CITY OF ALBUQUERQUE

RE: **McMahon Carwash**
McMahon and Fineland NW
Grading Plan Stamp Date: 7/30/18
Drainage Plan Stamp Date: 7/30/18
Hydrology File: A11D016A

Based on the submittal received 7/31/18, the Grading Plan and Drainage Report cannot be approved for until the following are corrected:

ENGINEER'S SEAL	McMAHON CARWASH	DRAWN BY WCWJ
		DATE 6-01-18
		218114-LAYOUT-5-24-18
		SHEET # —
		JOB # 218114
6/20/18	 <i>Rio Grande Engineering</i> 1606 CENTRAL AVENUE SE SUITE 201 ALBUQUERQUE, NM 87106 (505) 872-0999	
DAVID SOULE P.E. #14522

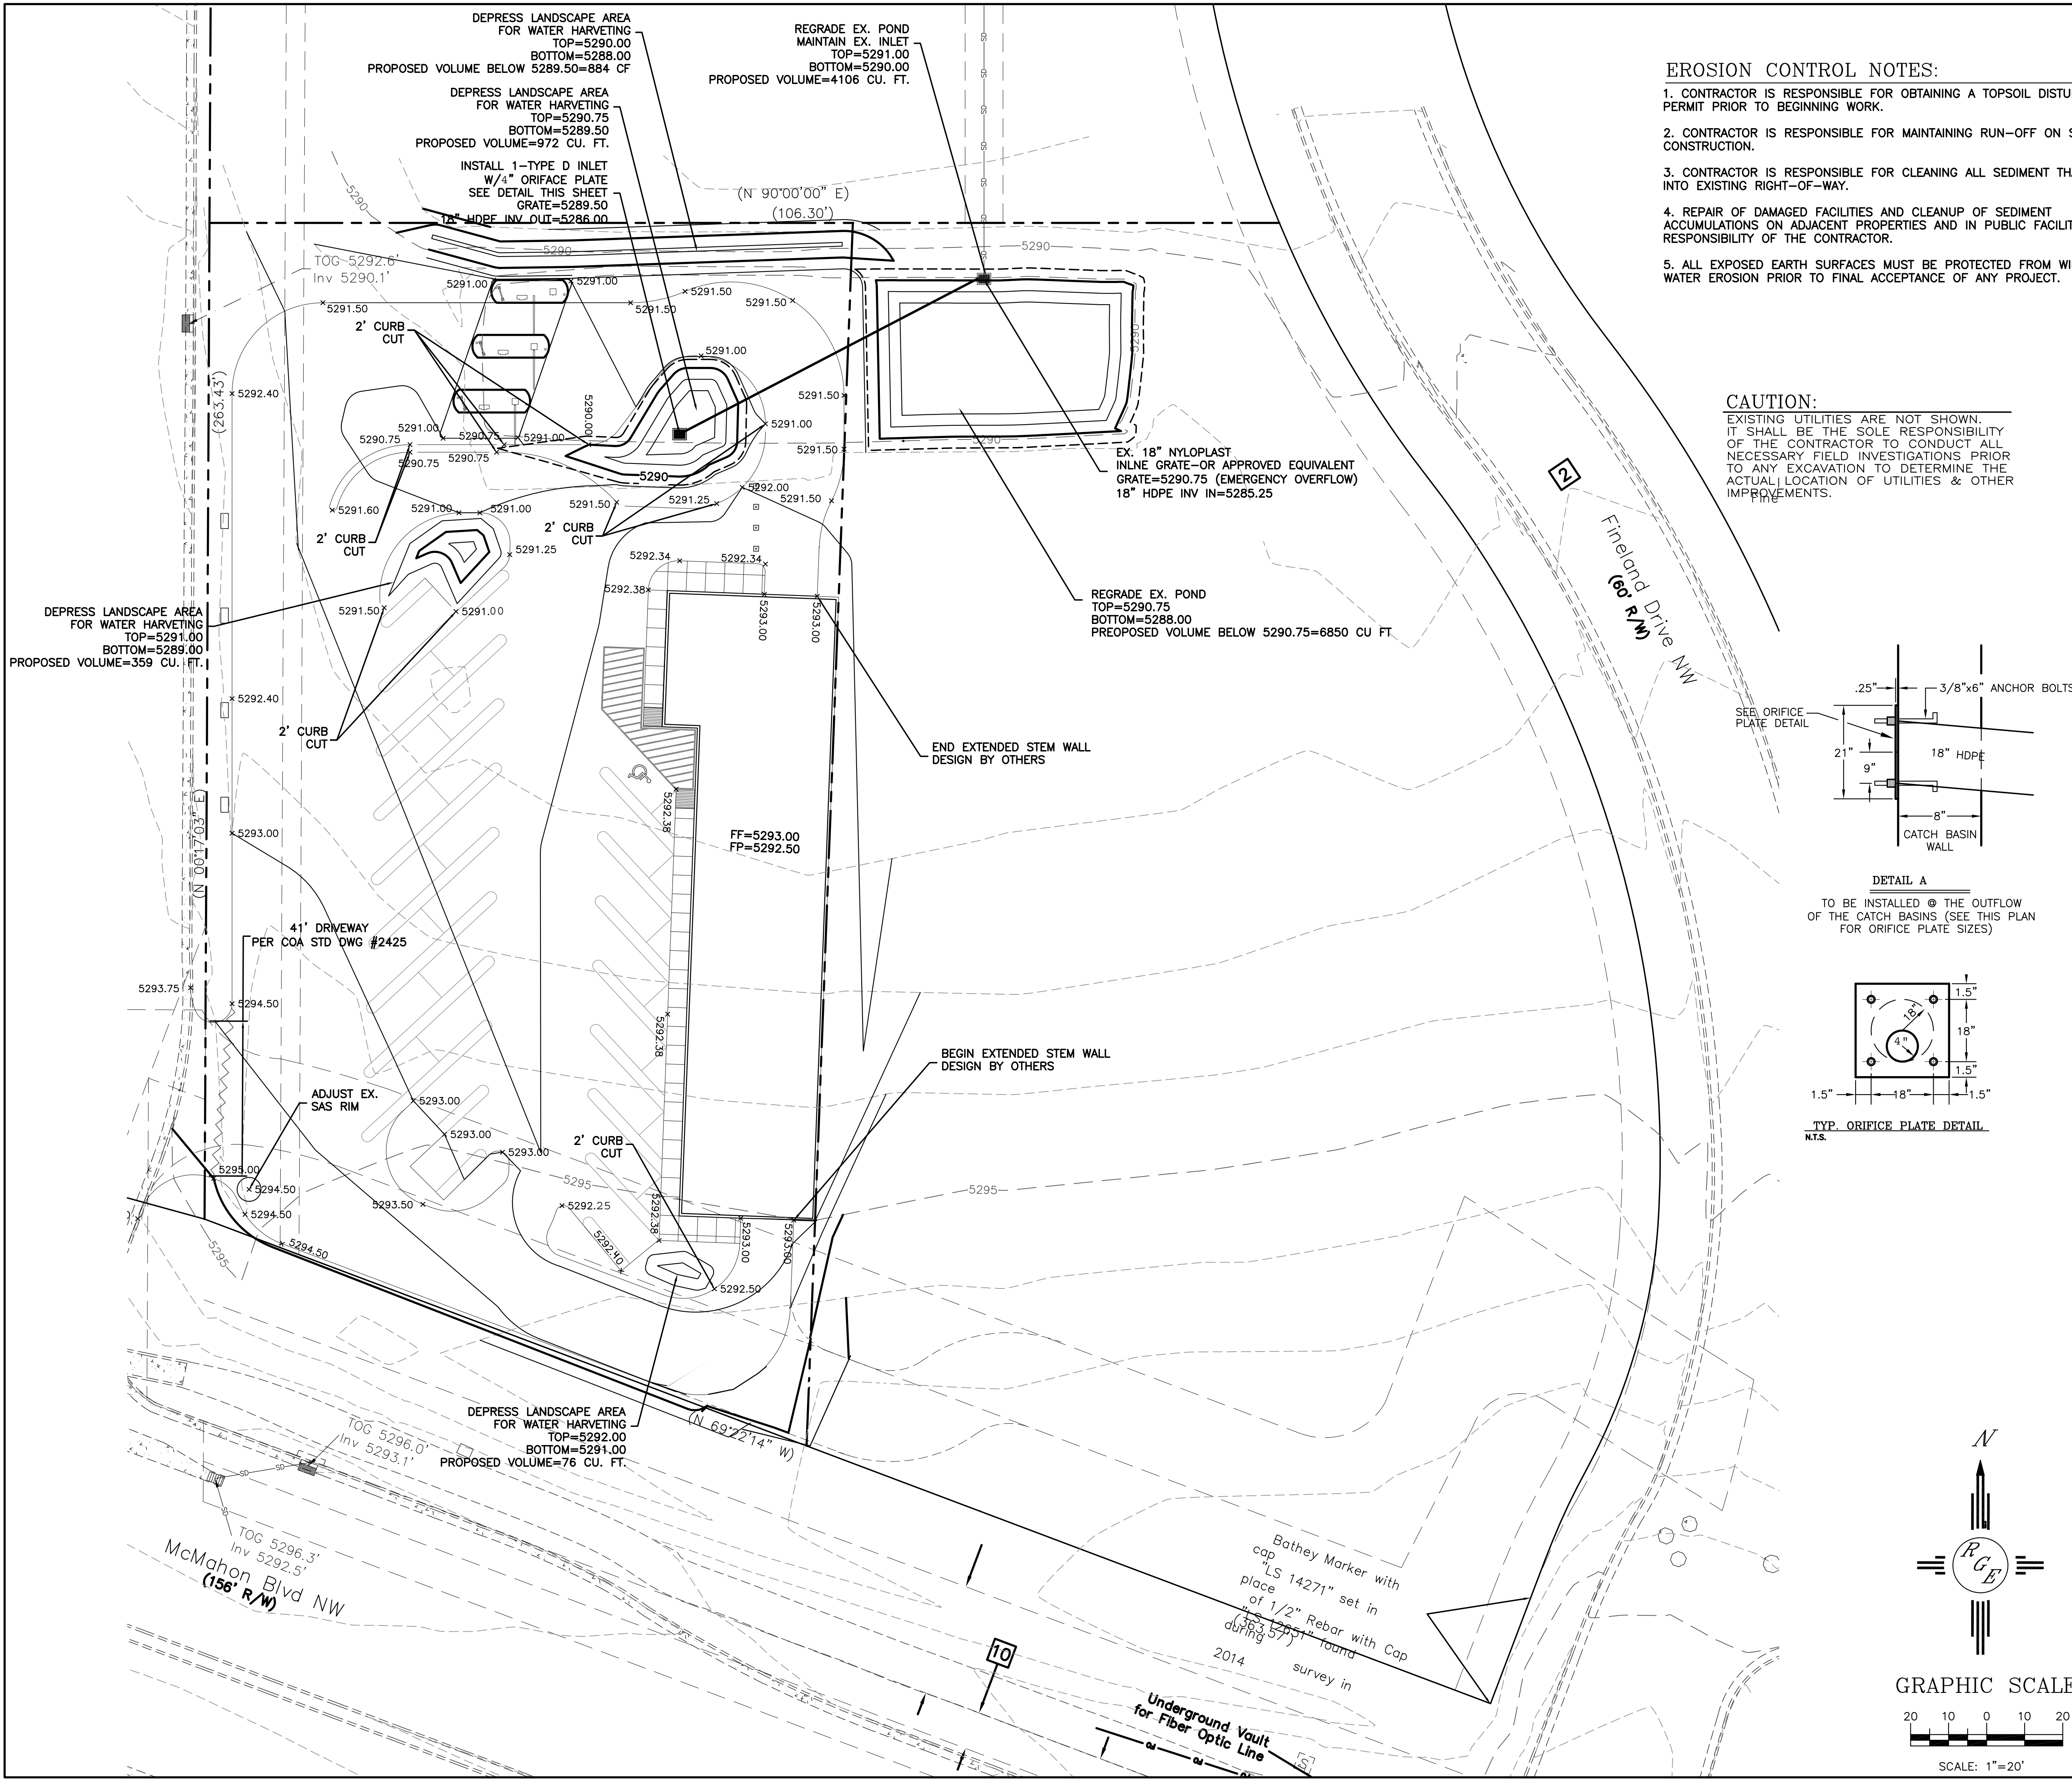
2. A digital (.pdf) submittal, emailed to PLNDRS@cabq.gov is required.
3. The first flush retention areas need to be clarified. The 4 small ponds in West Basin need to be sized for the areas drainage to each of them. The north pond is higher than the parking lot and nothing seems to drain to it. The center pond has the grate elevation set to provide only 855cf of the required 1153cf volume. The areas draining to the 2 south ponds need to be quantified and the ponds sized to retain these first flush volumes.
